KITTTITAS COUNTY COMMUNITY DEVELOPMENT SERVICES

RE: Survey Revisions Needed.

Kittitas County Community Development Services (CDS) accepted your application for the proposed Boundary Line Adjustment (BL-17-00021) on October 30th, 2017. The application was deemed complete on December 1st, 2017, and conditional preliminary approval was granted on December 26th, 2017. Kittitas County Code 16.10.040 reads:

<b>BOUNDARY LINE ADJUSTMENT</b>	
PREPARED FOR	
PAT DENNEEN	
A PORTION OF THE SOUTHWEST 1/4 OF SECTION 15, TOWNSHIP 22 NORTH, RANGE 11 EAST, W.M., KITTITAS COUNTY.	
TOWN BY	JOB NO. WASHINGTON
D.L.P./G.W.	DATE 05/2018
CHKD BY	SCALE N/A
D.L.P.	SHEET 4 OF 4

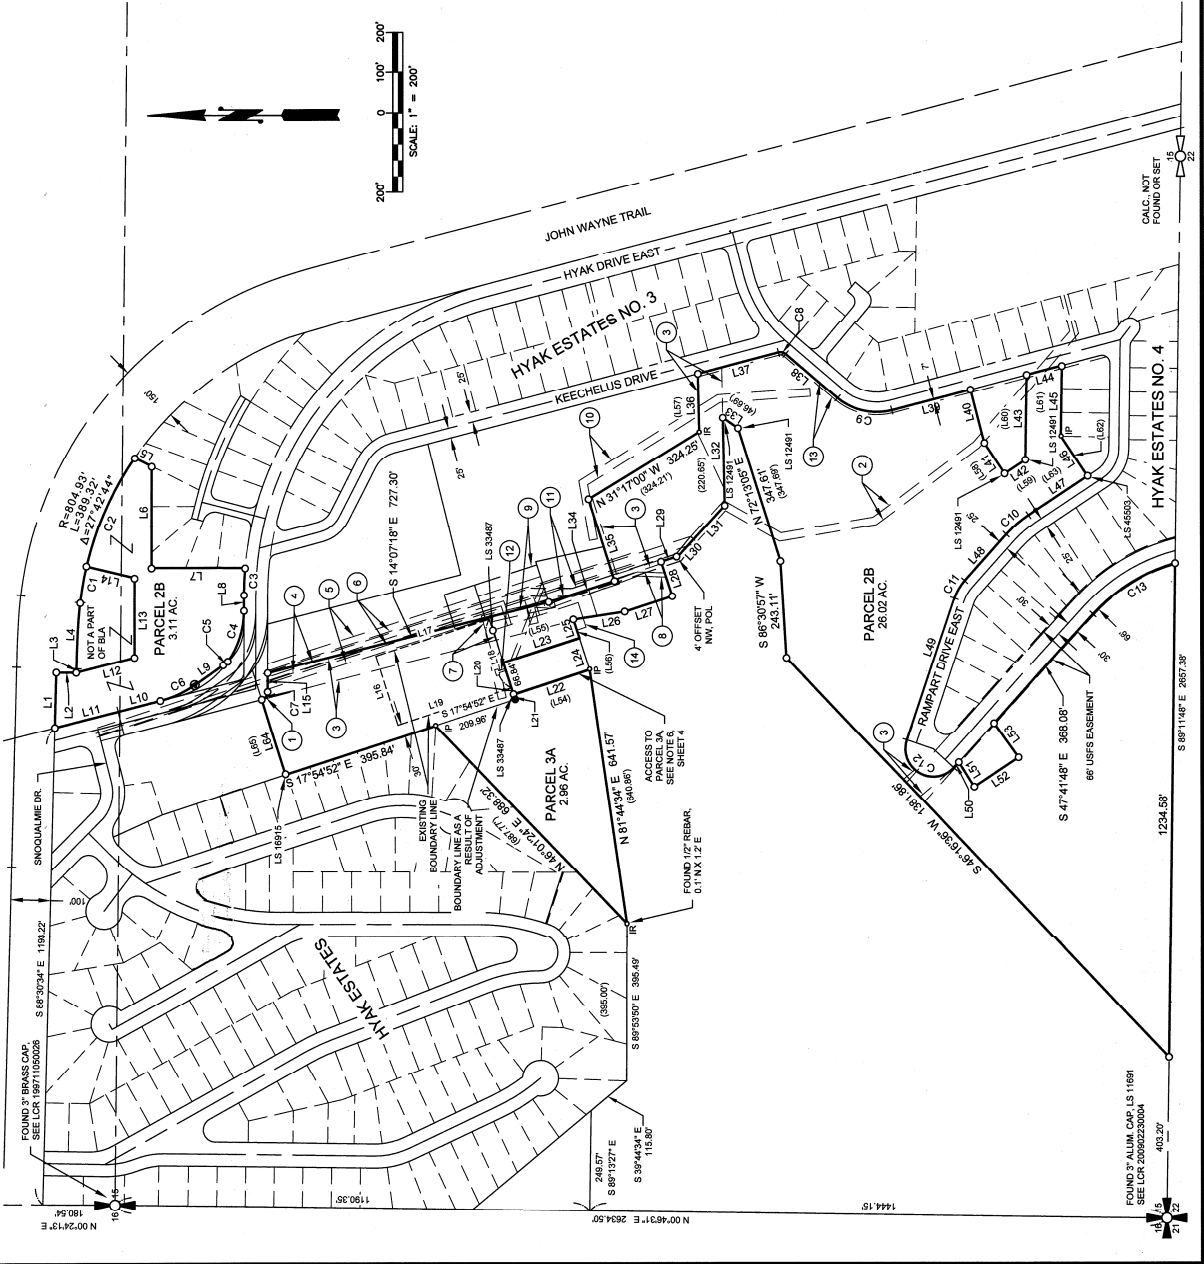
As submitted, the survey properly depicts the two disconnected tracts of land as the same parcel, 2B. However, the legal descriptions as a result of the adjustment on page 4 of the survey documents list the tracts as parcels 2 and 2B. This confusion between the legal descriptions and the drawings can potentially create the impression that the two tracts are separate developable and sellable lots.

In order to prevent confusion for future buyers, sellers, developers, and County agencies, a revised survey with accurate legal descriptions must be submitted. Please see the attached staff marked up recorded survey (sheet 4) for suggested changes to make it clear that Parcel 2B, while two disconnected tracts of land, is in fact one parcel for land use purposes. Again, this language is only a suggestion as to how to remedy the legal description; please have your surveyor use the industry accepted verbiage for linking these descriptions.
